**ADC Planning Consultation
Response from the Conservation Officer**

Application Number	LU/313/14/PL
Address	11 St. Winefrides Road Littlehampton BN17 5HA
Description	Demolition of existing dwelling & erection of 4 No. 3 bed detached dwellings with single detached garages
Case Officer	Mrs. A Gardner

Plot 1 - 3 Bedroom House

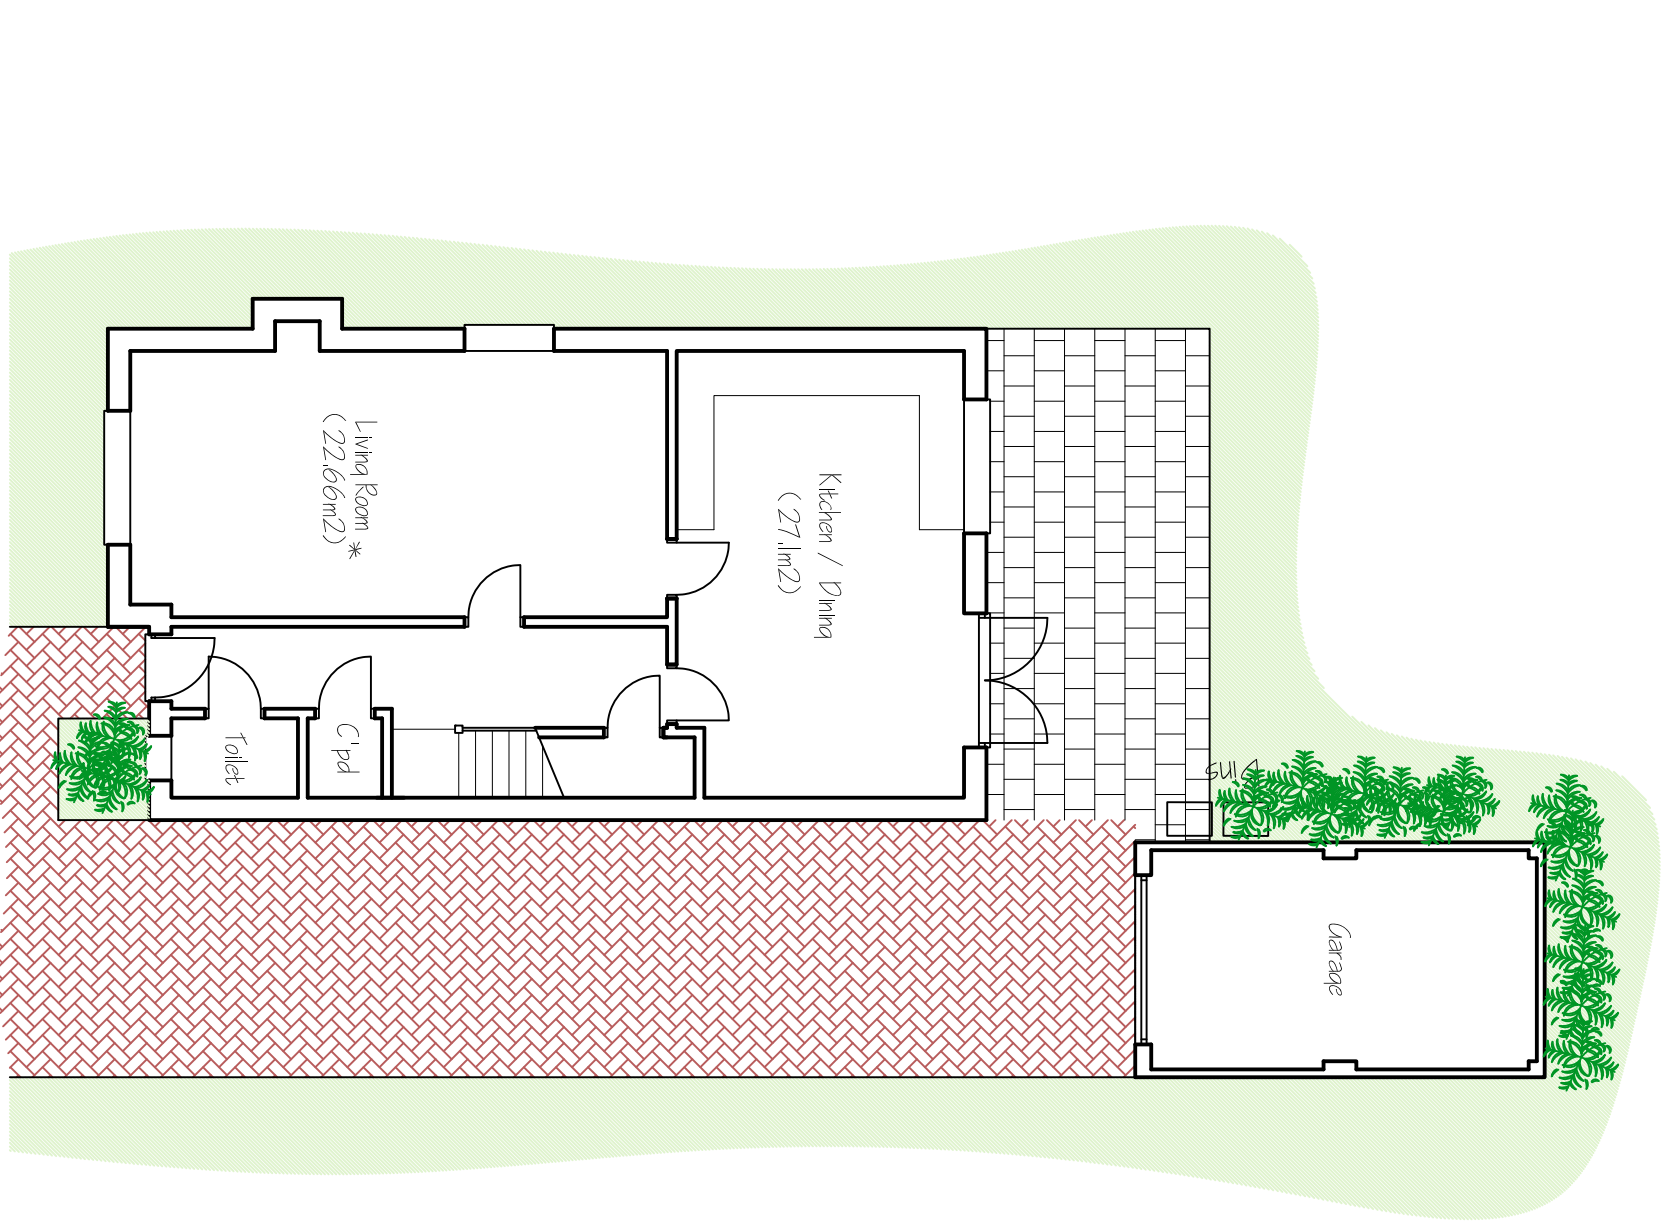
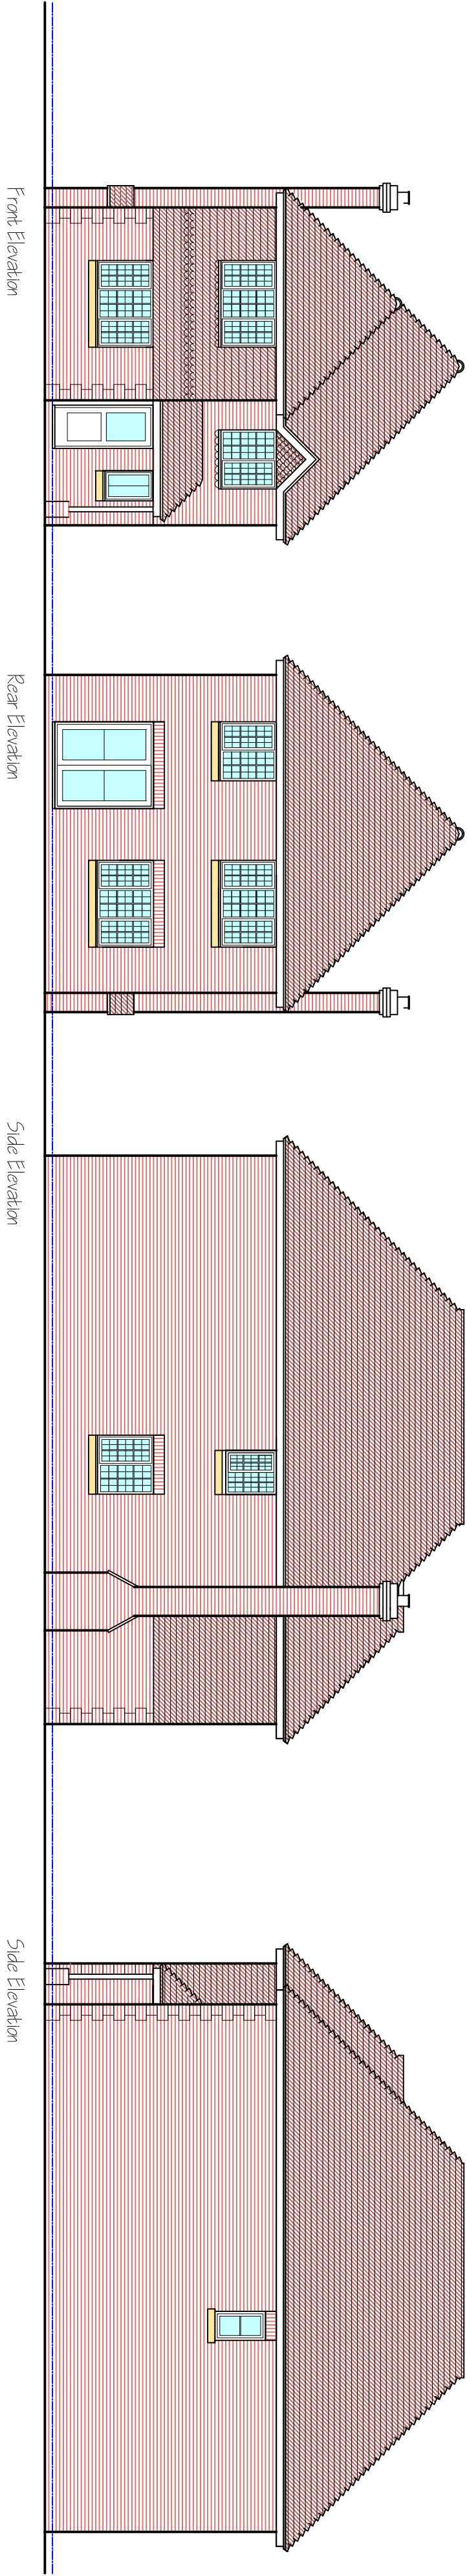
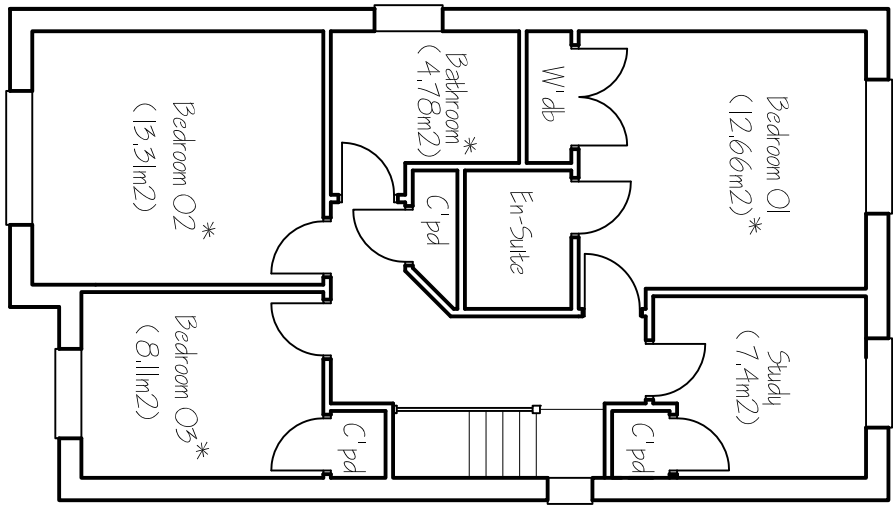
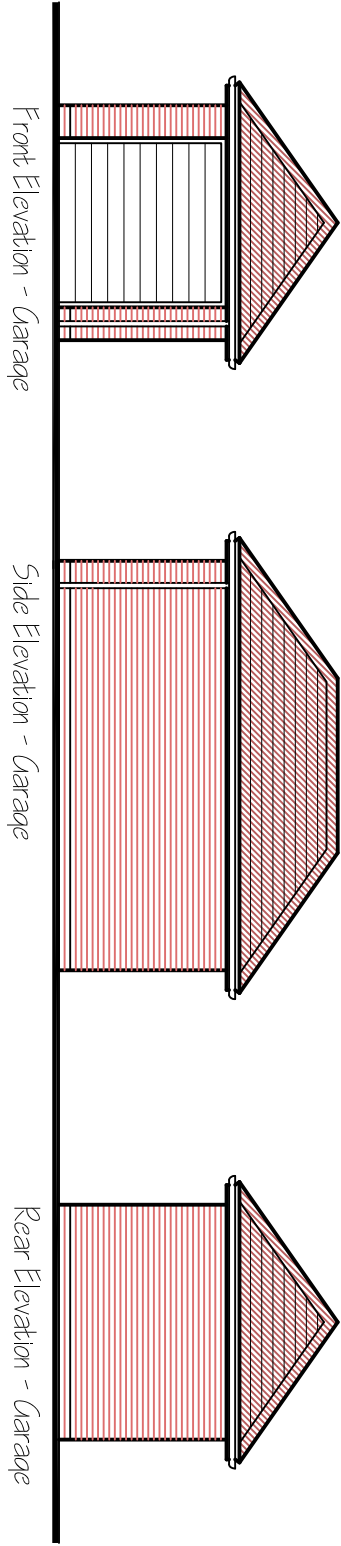
However, there are concerns with the proposed replacement structures, when viewed in context the new properties are smaller than those that surround them. This is especially true when compared to those properties opposite.

It is noted that the properties along this side of the road vary in design and appearance. However, the proposed properties themselves are essentially all the same, with slight variations. The choice of materials is also questioned; there does not appear to be any flint in the locality. Instead there appears to be a mixture of render, brick, tile and 'Mock-Tudor'.
